Subject: Re: RE: Planning Application Ref. R/105/15/PL

JOB number:	drawing number:	revision:
2082	(11)001	1
project:	Princess Marina House	
client:	Seaside Apartments	
client:	RAF Benevolent Fund	
title:	Parking Plan	
date:	22/04/15	scale:
	1:100 @ A1	drawn: GT
		checked: CS

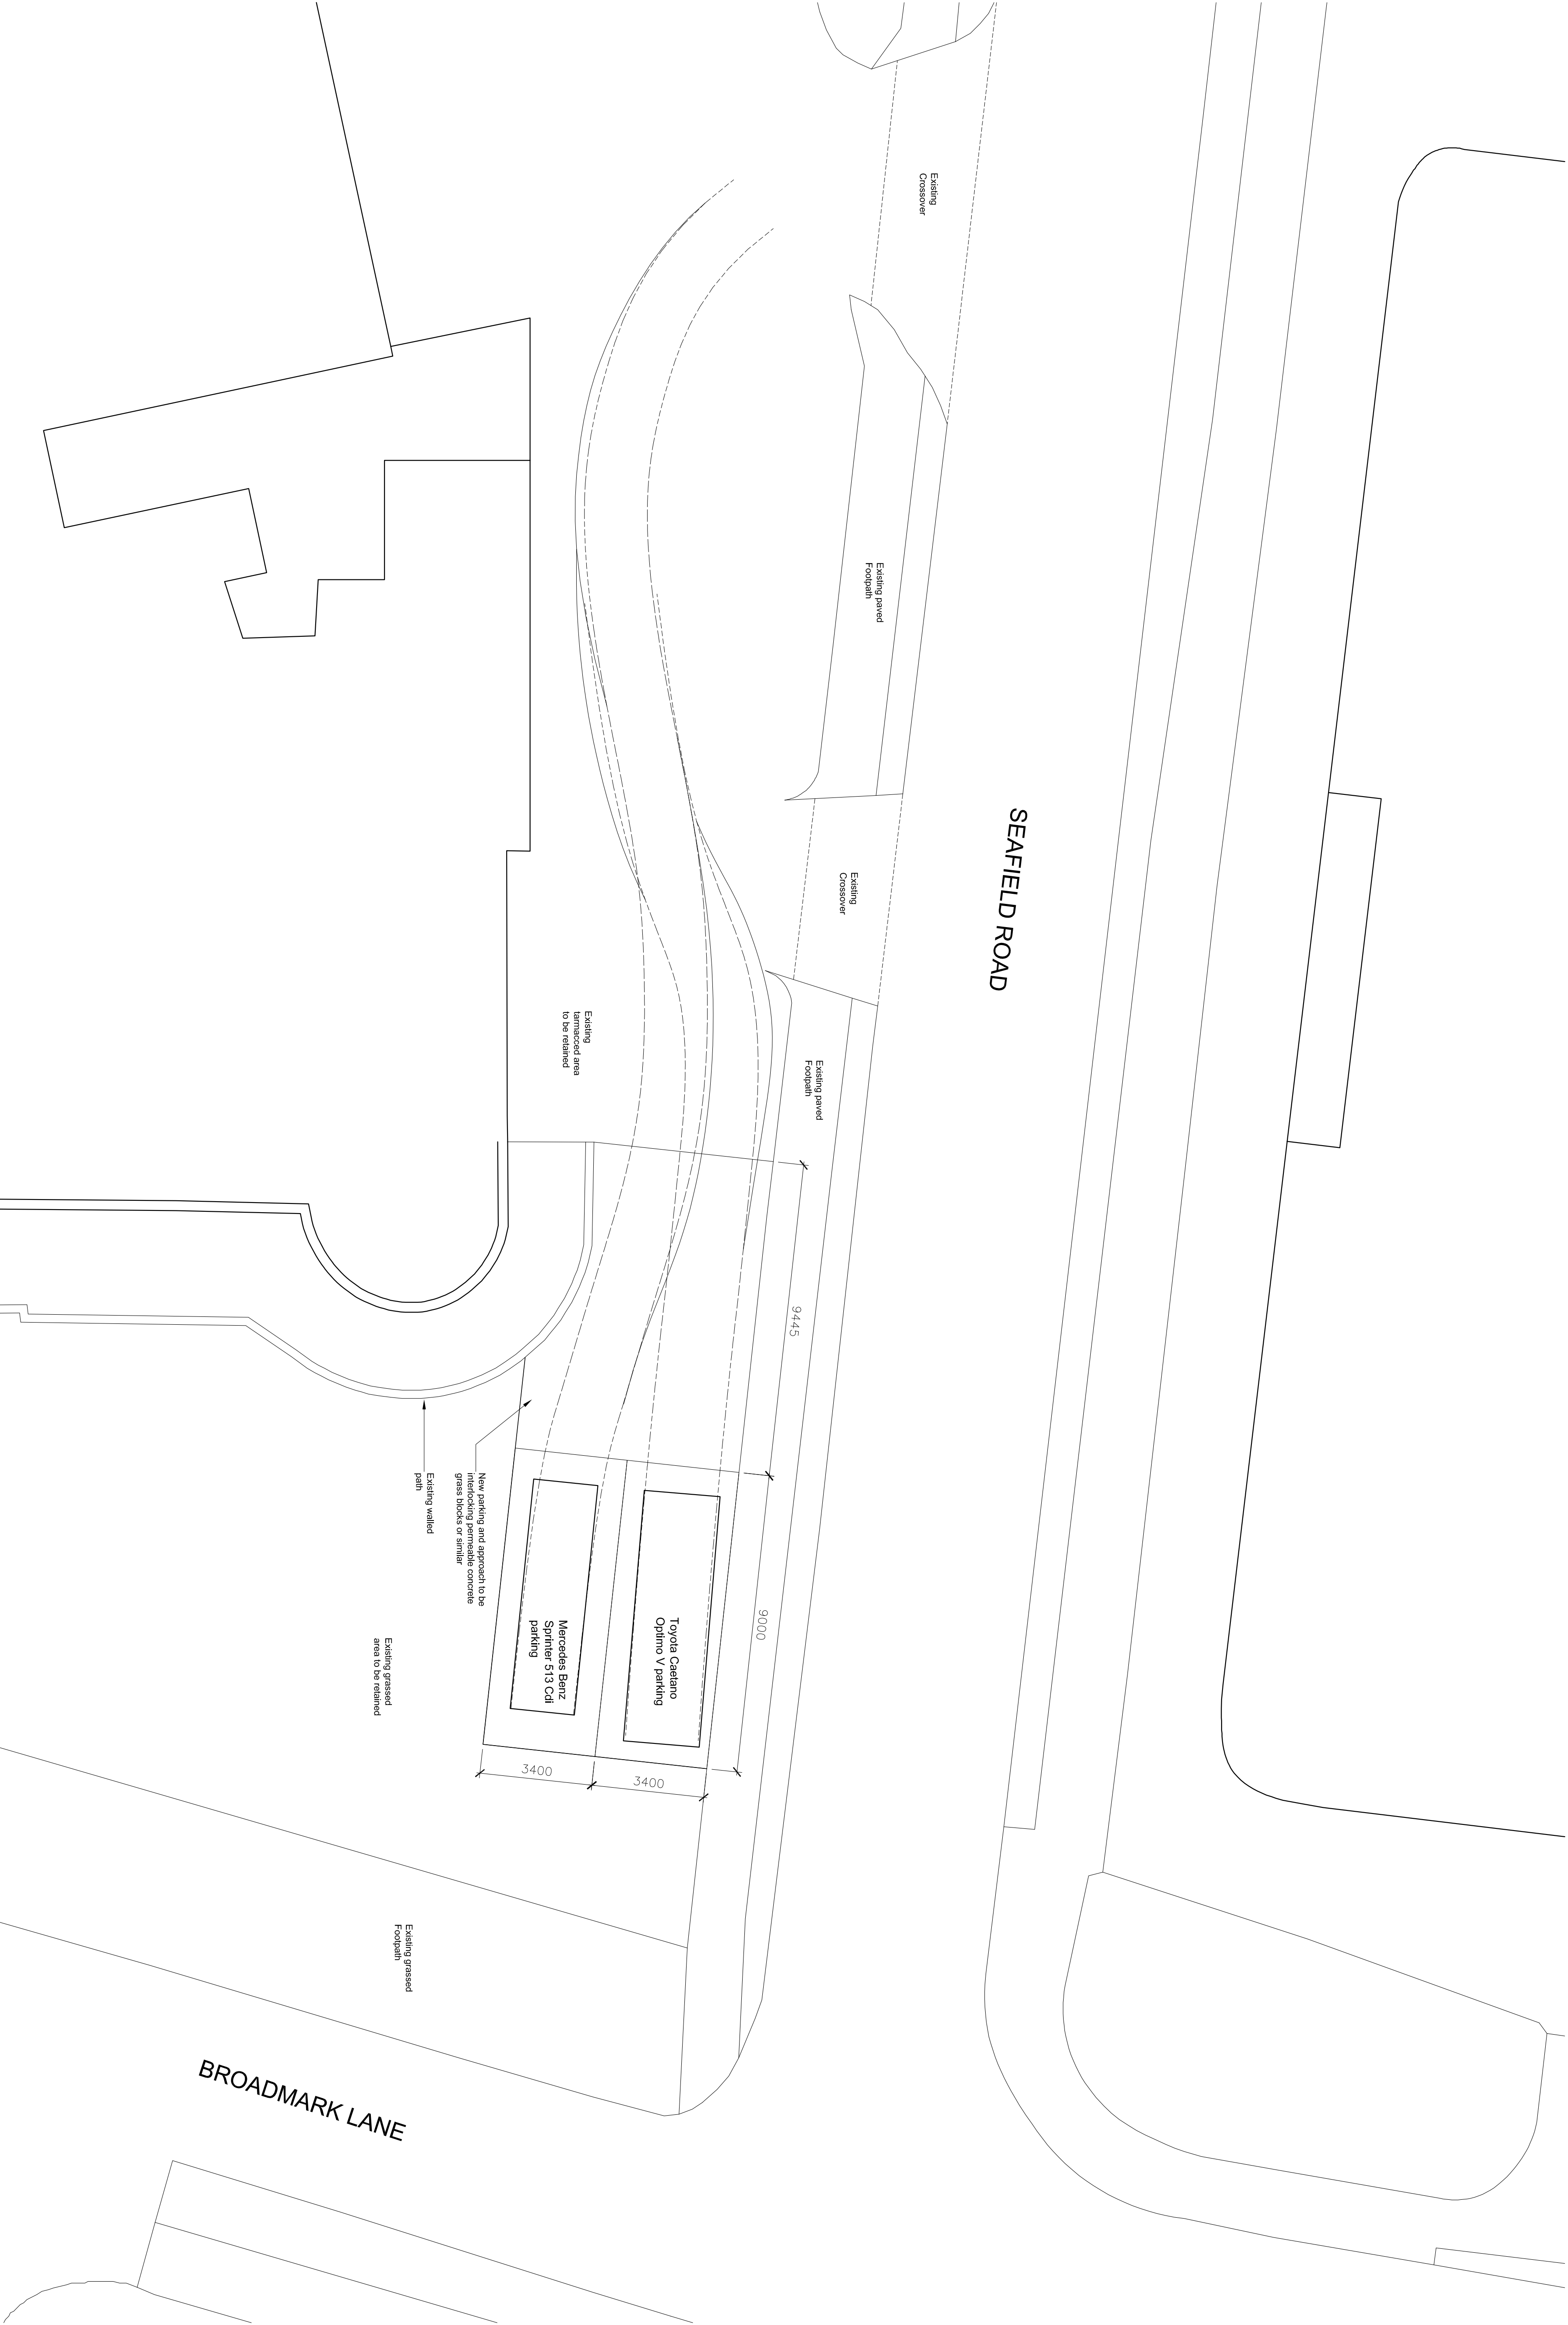
Thank you for your reply. I would like to supplement my previous comments by pointing out that, to my mind, this proposal goes against the Rustington Neighbourhood Plan in as much as it would detract from the character of our village and the overall street scene as one looks down Broadmark Lane and across Princess Marina House grounds to the sea and it would not complement it's immediate surroundings. In addition the Plan requires the preservation of the seafront/greensward vista which I don't think this proposal does even though it is not on the actual greensward it is extremely close to it. The Neighbourhood Plan also states that development should not detract from the character and amenity of the nearby area and also should not impact on surrounding properties but should seek to maintain privacy and alleviate possible noise issues to existing neighbouring properties. In my opinion the parking of two minibuses/coaches where proposed would directly impact on our property and privacy, as would the noise of their engines and the beeping of their reversing signal which is already loud from their existing parking areas so to bring even closer and directly across from our property would adversely affect us.
